Our Ref: A/94/12/CLP
Your Ref:

Application for Lawful Development Certificate for a Proposed Use or Development

Development Application for a Lawful Development Certificate for a proposed use - rear extension

Location Fairway Ham Manor Way Angmering

Ham Manor extension
Block Plans
1:500 @ A4

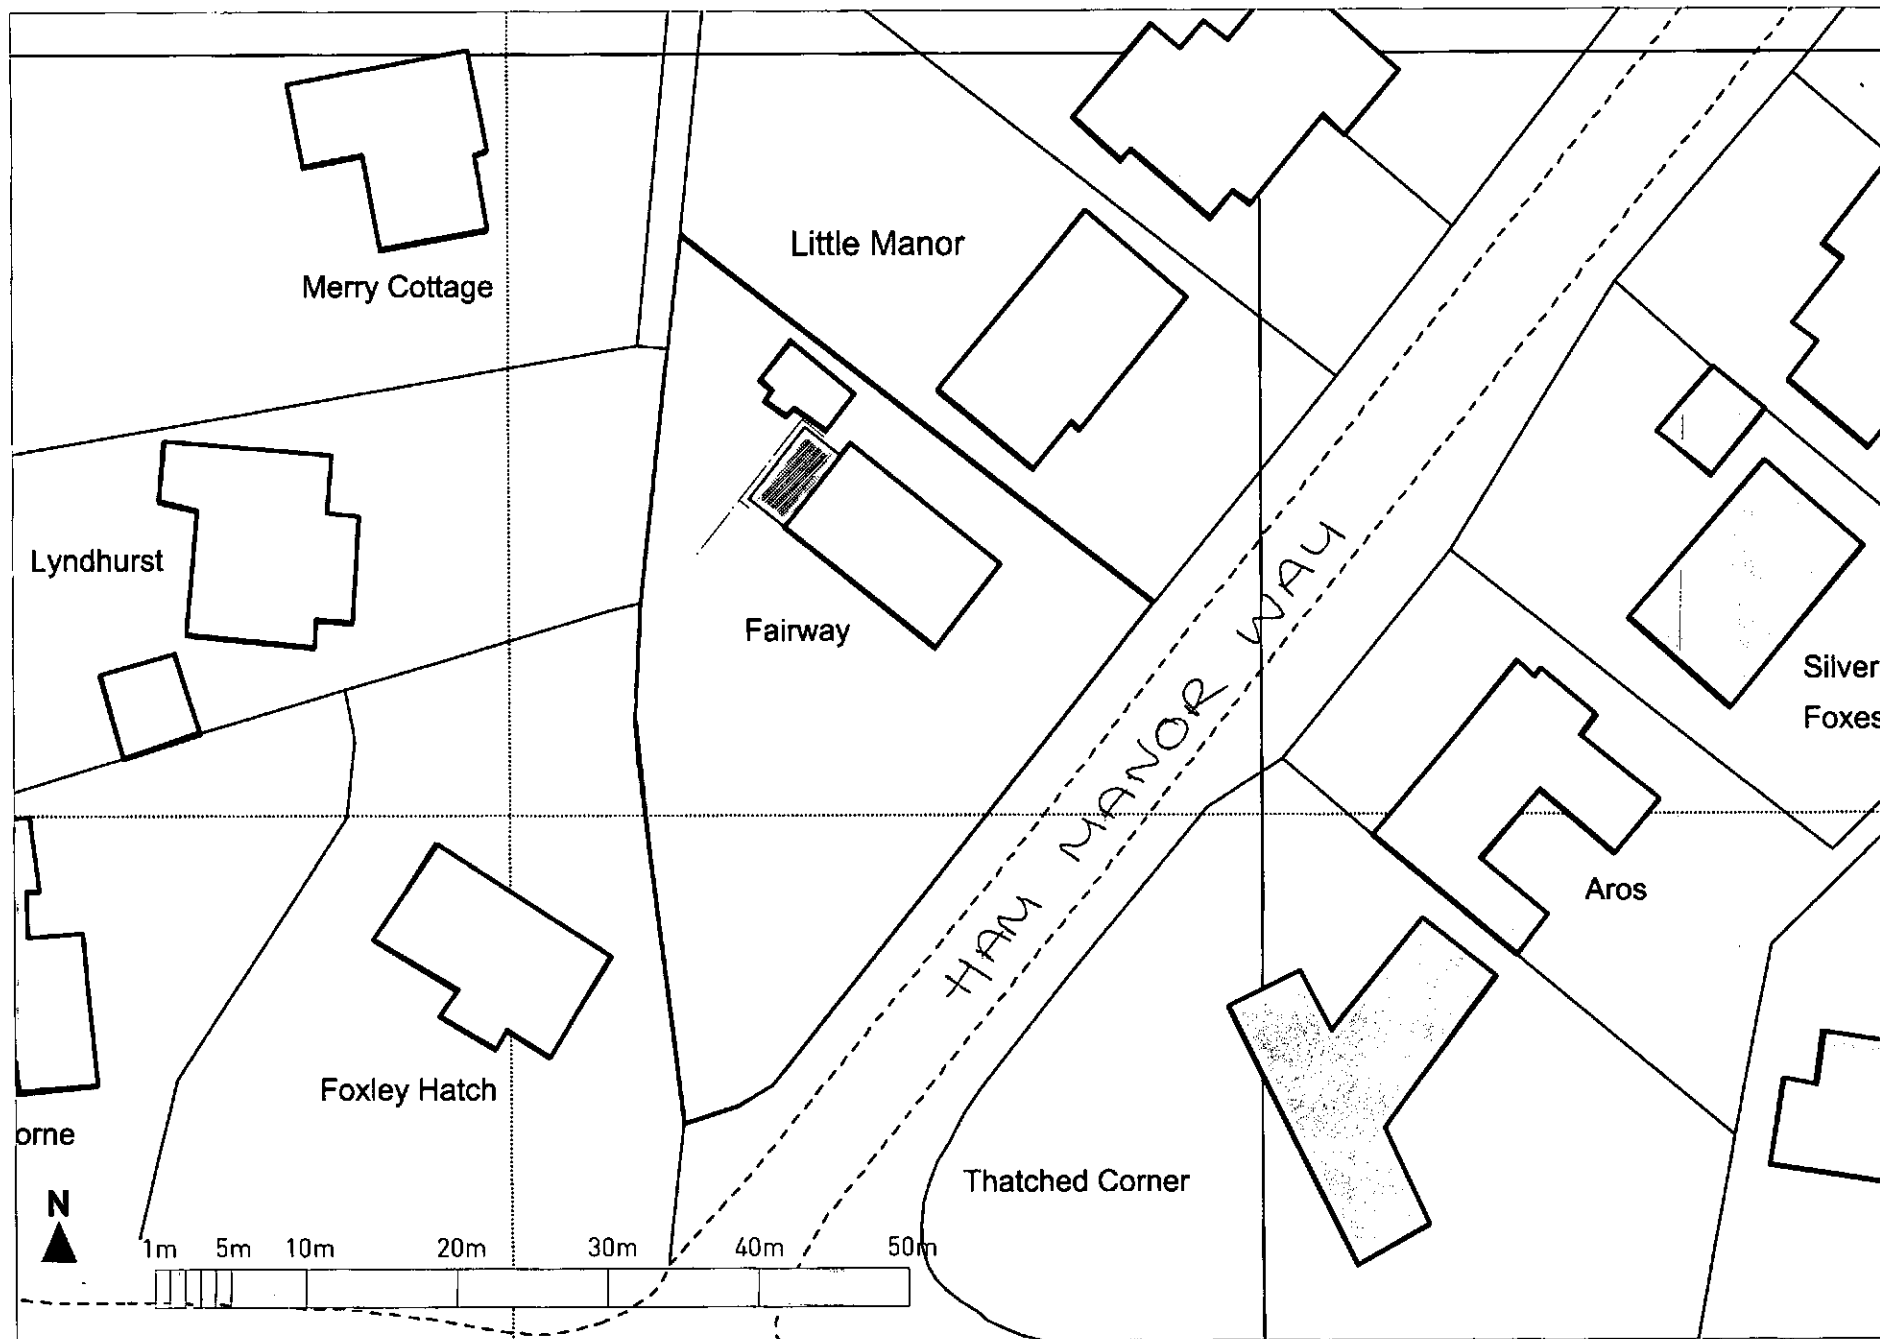
Please submit 3 amended block plans to show 1 named road

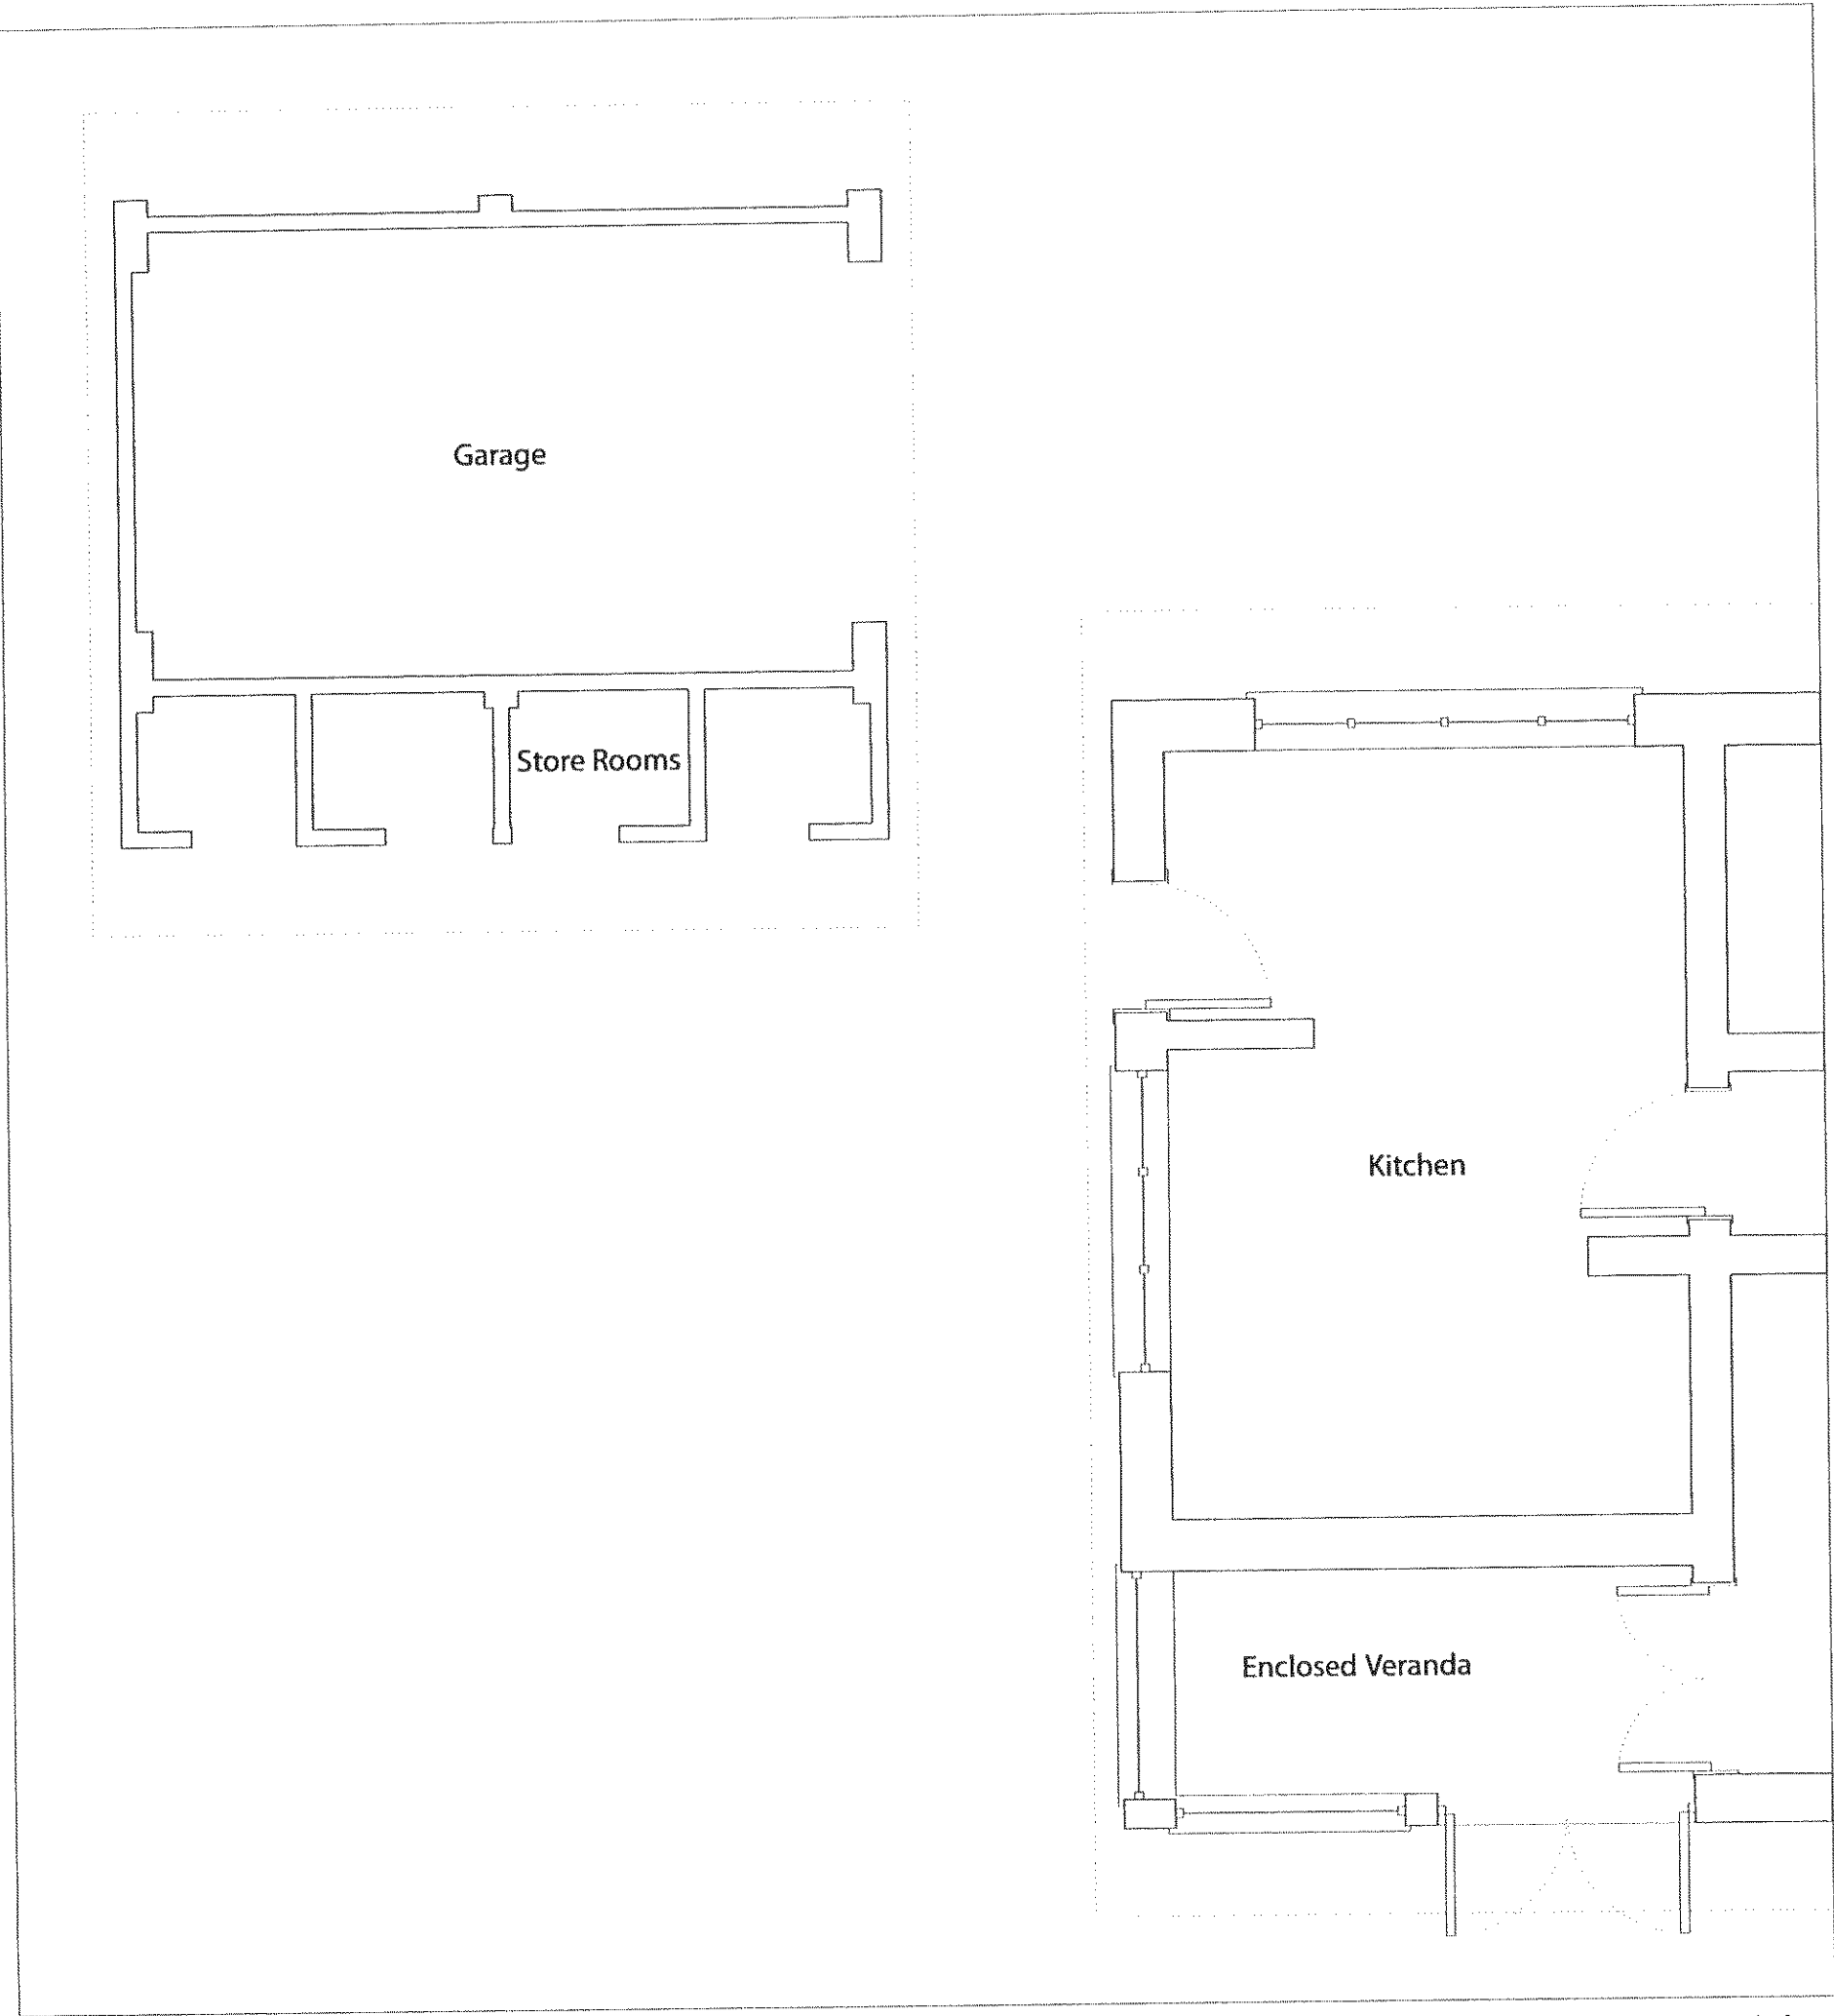
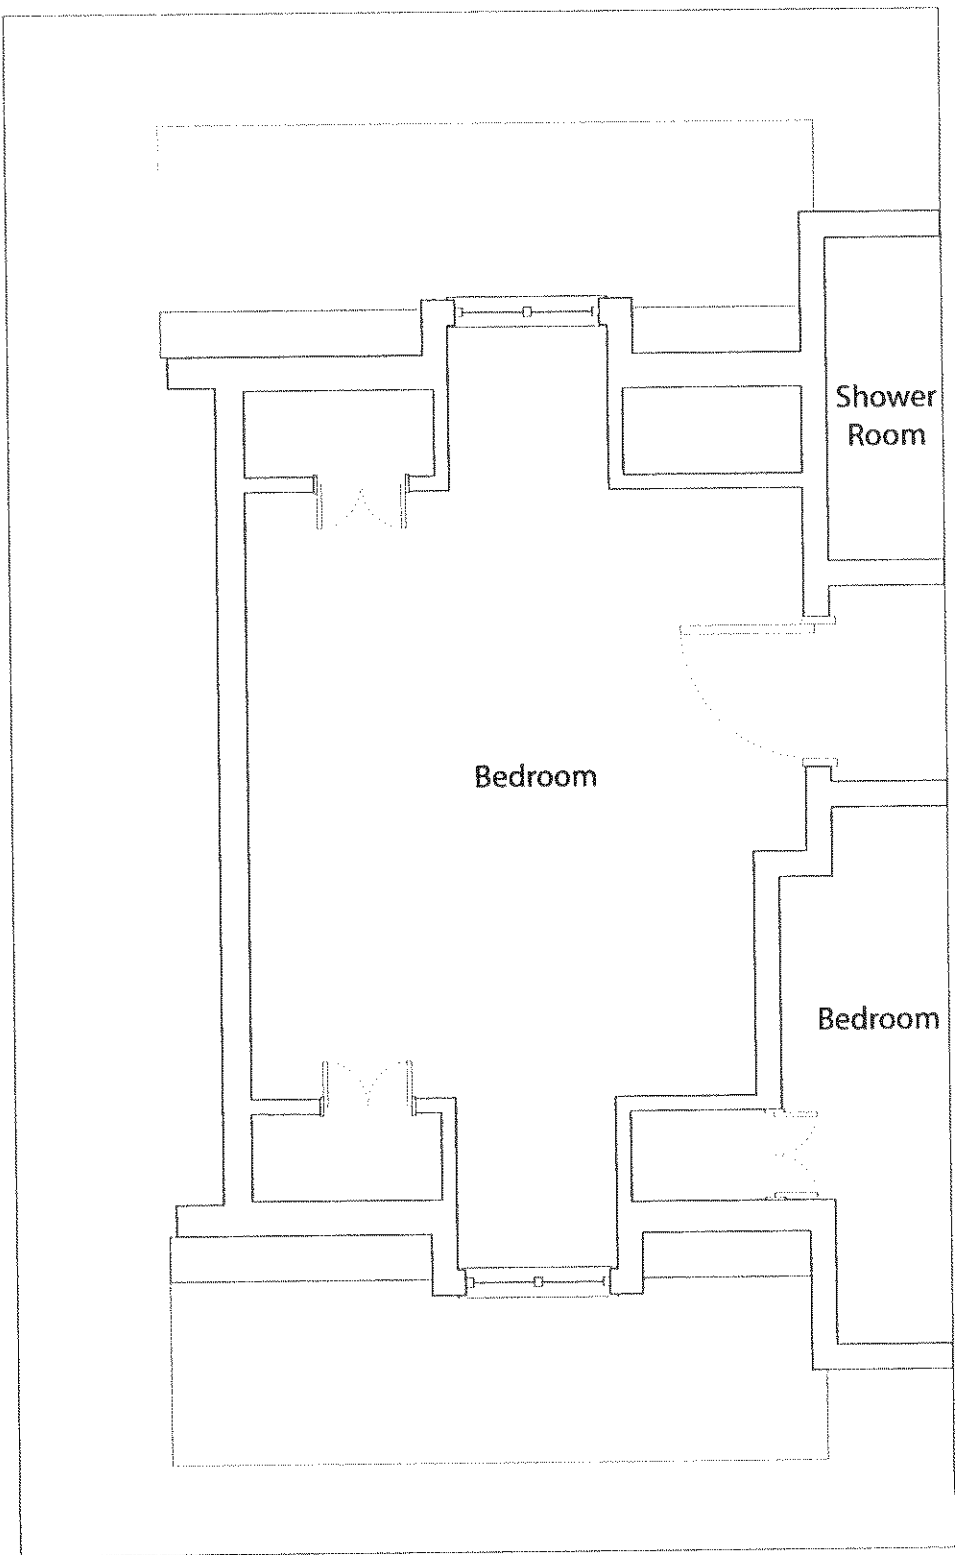
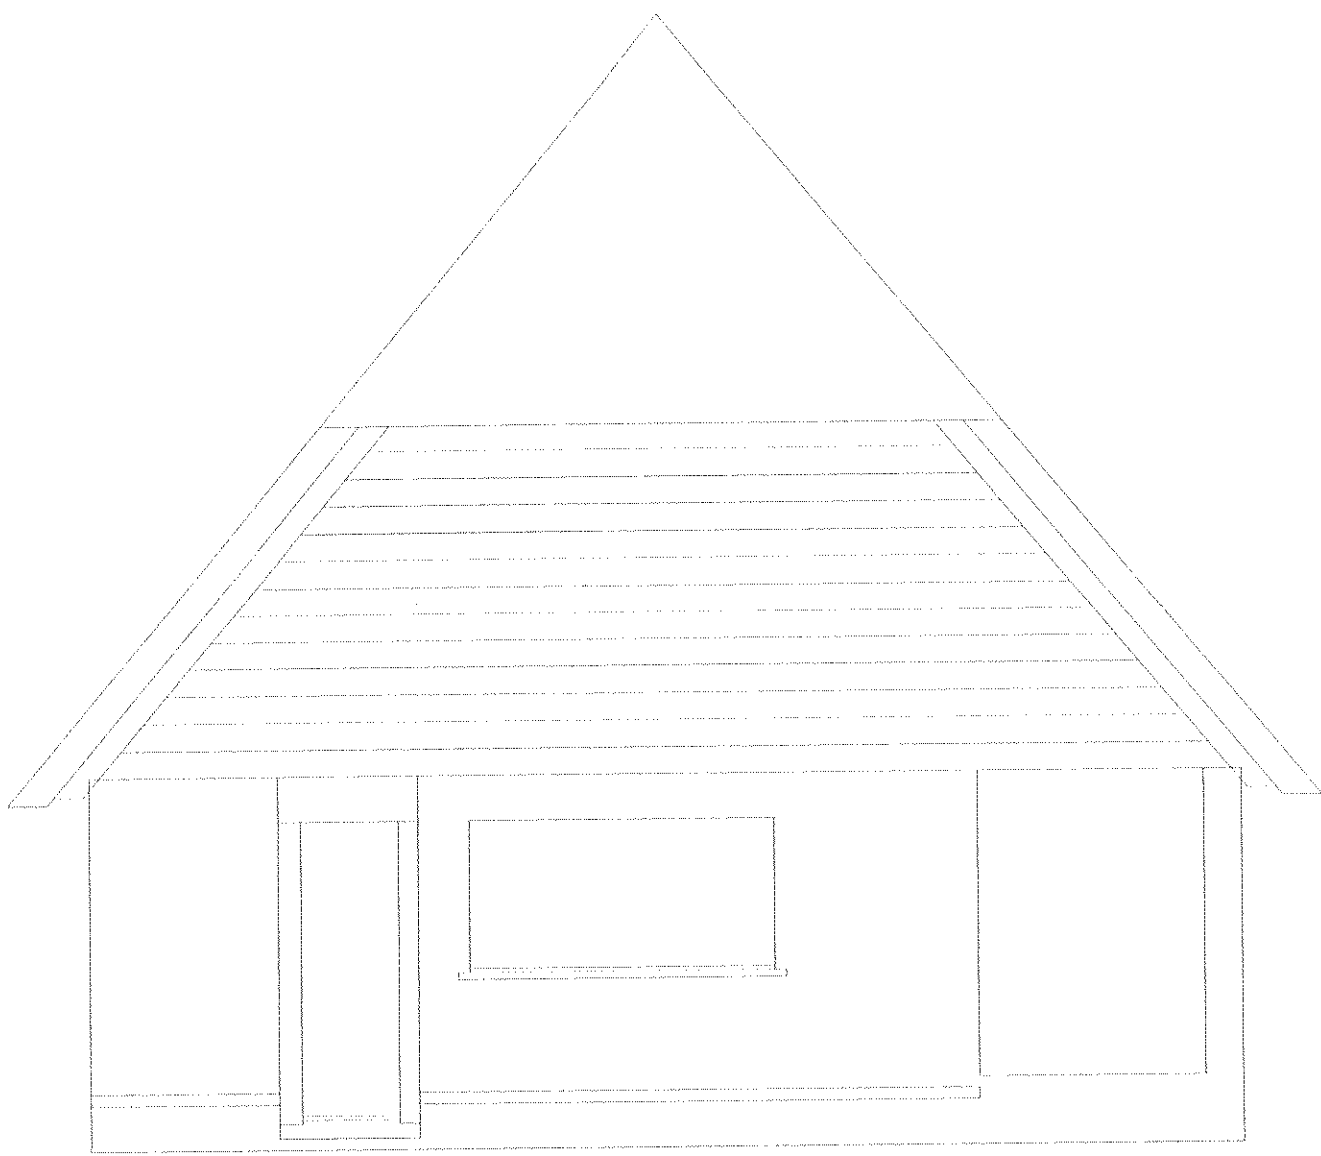
Please submit 3 copies of existing floor and elevation plans (showing all elevations)

Please submit 3 copies of rear elevation plans
